Rezoning Transportation Analysis

Petition Number: 2020-050

General Location Identifier: Tax ID 14913365

Date	Description
040-220-2020	First Review
05-15-2020	Second Review (MM)

**RZ-2**

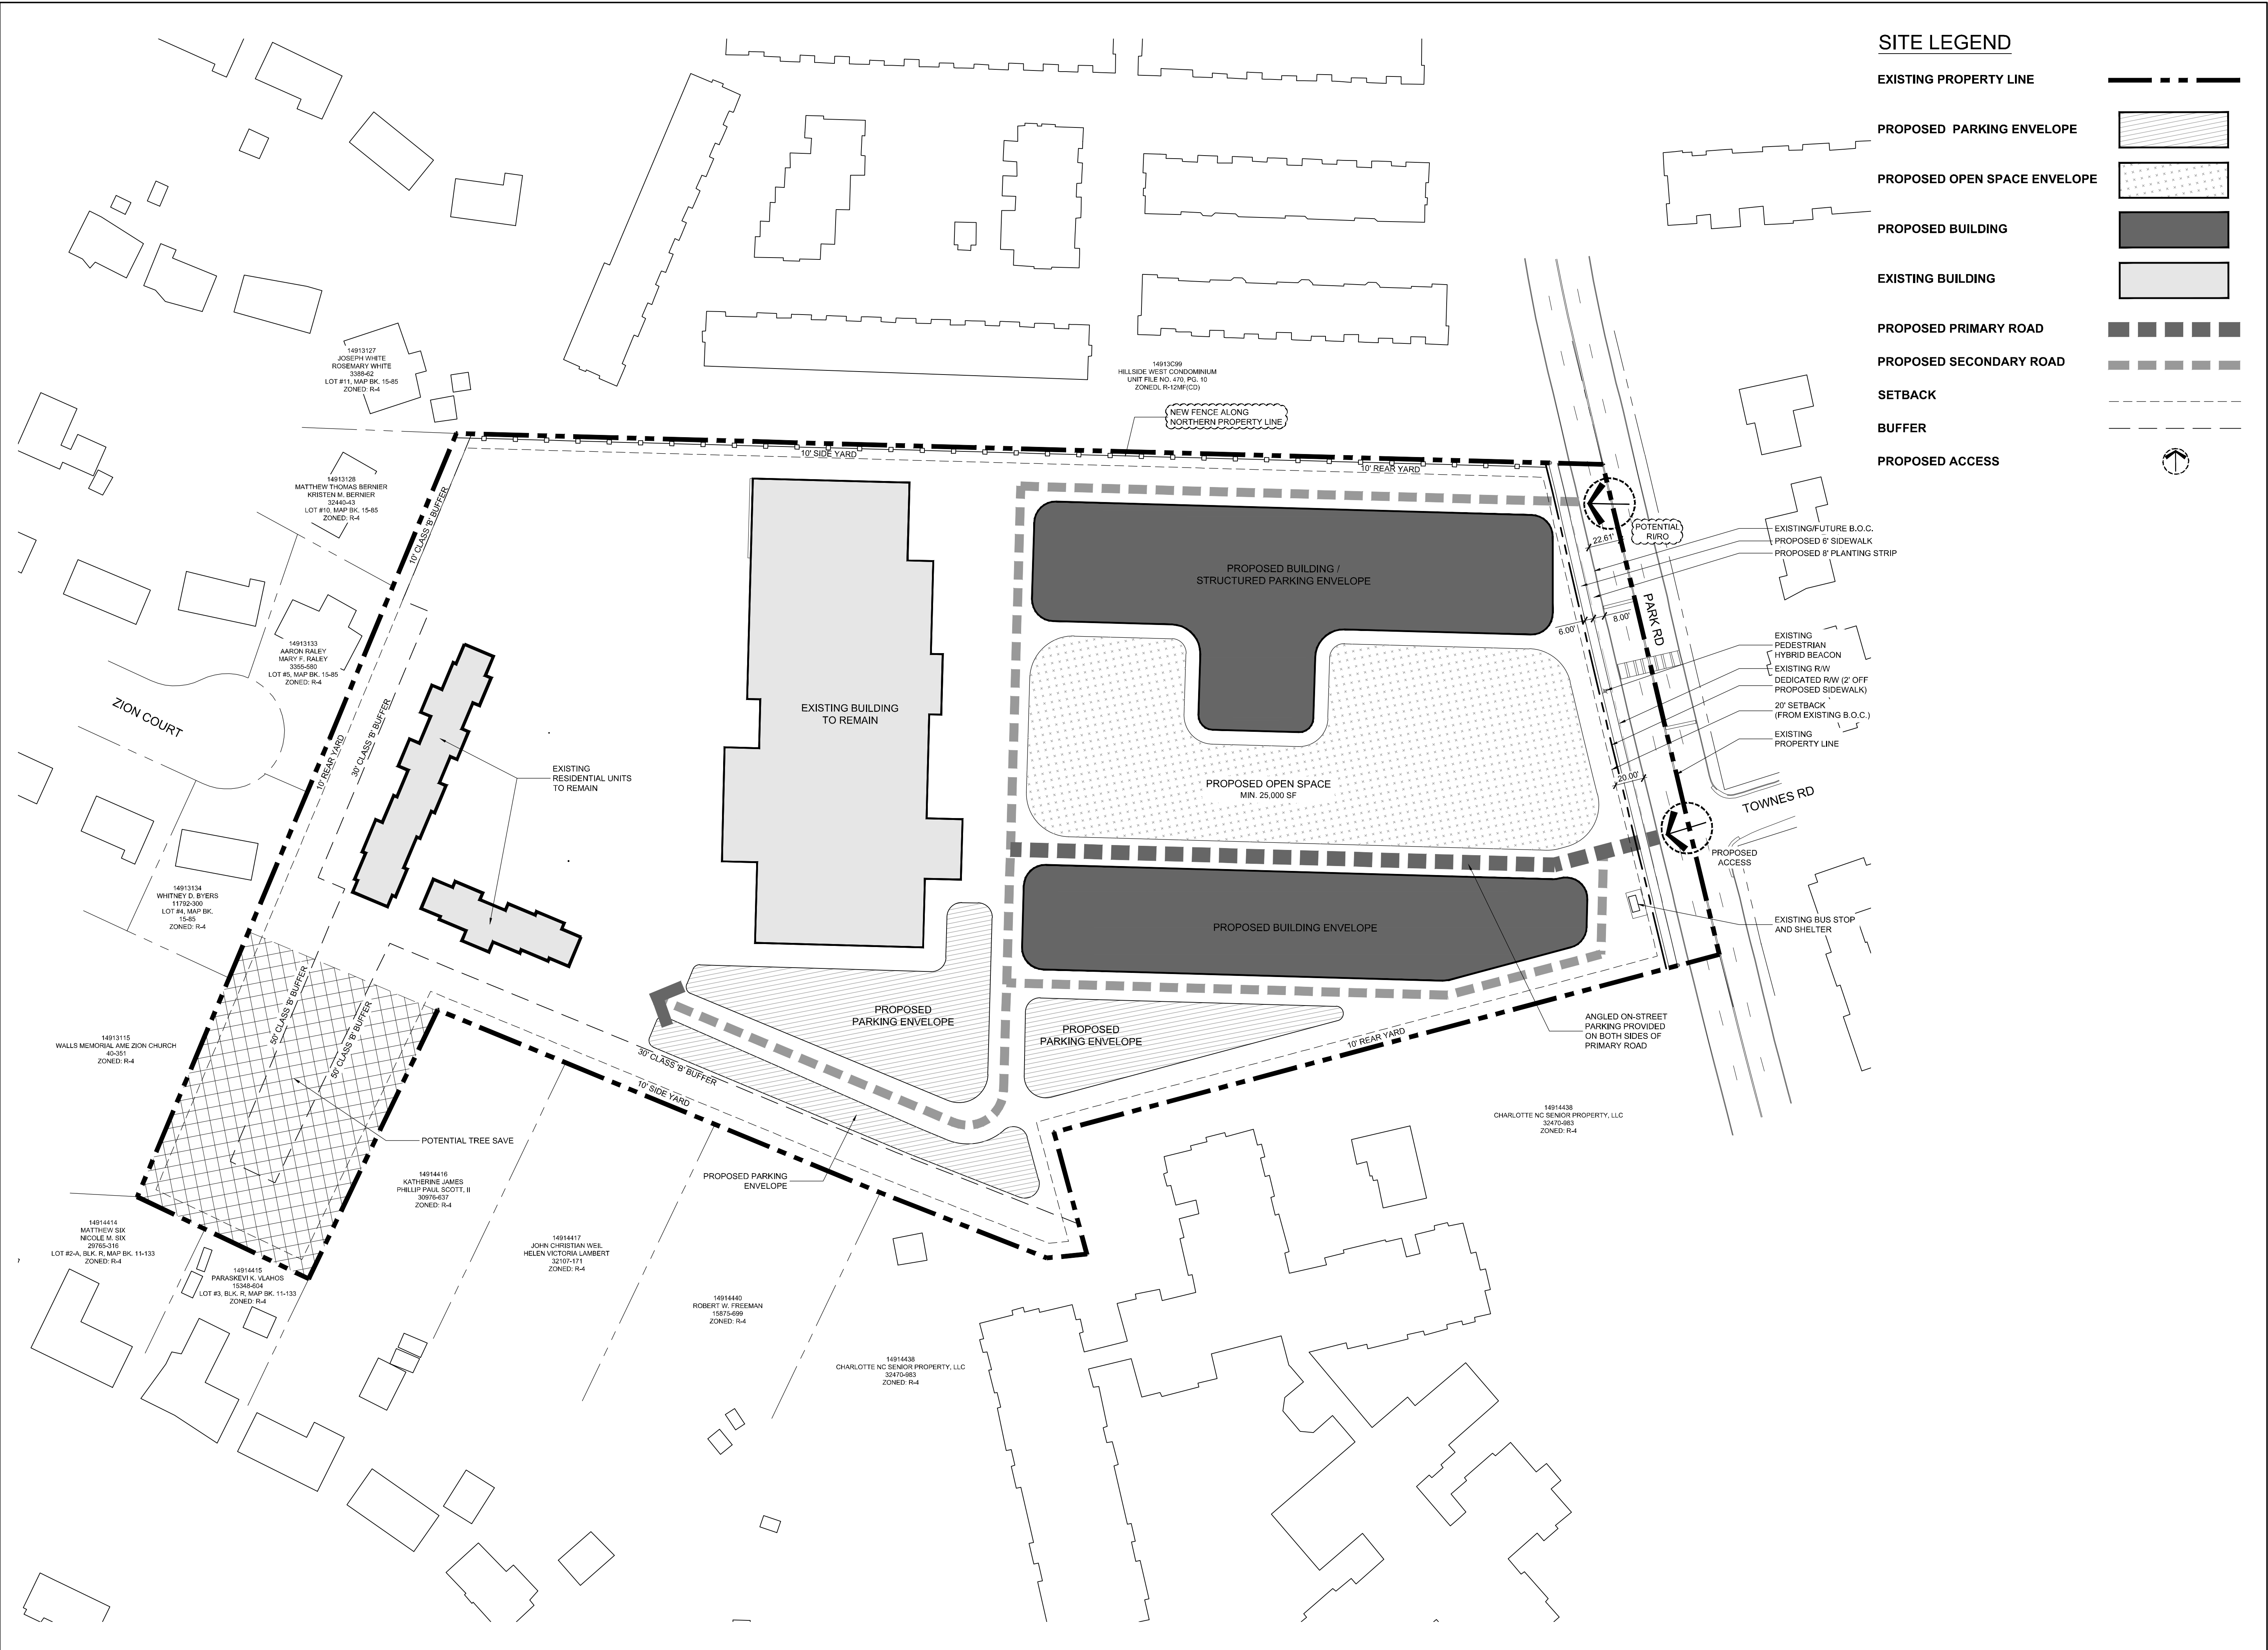
3. ~~The petitioner should revise the site plan on Sheet 1 to show the dimensions for the 6-foot sidewalk and 8-foot planting strip and update the conditional note 5.b. to state that the petitioner will commit to construct an 8-foot planting strip, and 6-foot sidewalk on Park Road.~~

4. ~~The petitioner should revise the site plan and conditional note(s) to indicate the locations of the existing bus stops and pedestrian hybrid beacon in front of the YWCA.~~

5. ~~The petitioner should revise the site plan to add a note specifying dedication and fee simple conveyance of all rights of way to the City before the site's first building certificate of occupancy is issued. CDOT requests right of way set at 2' behind back of sidewalk where feasible.~~
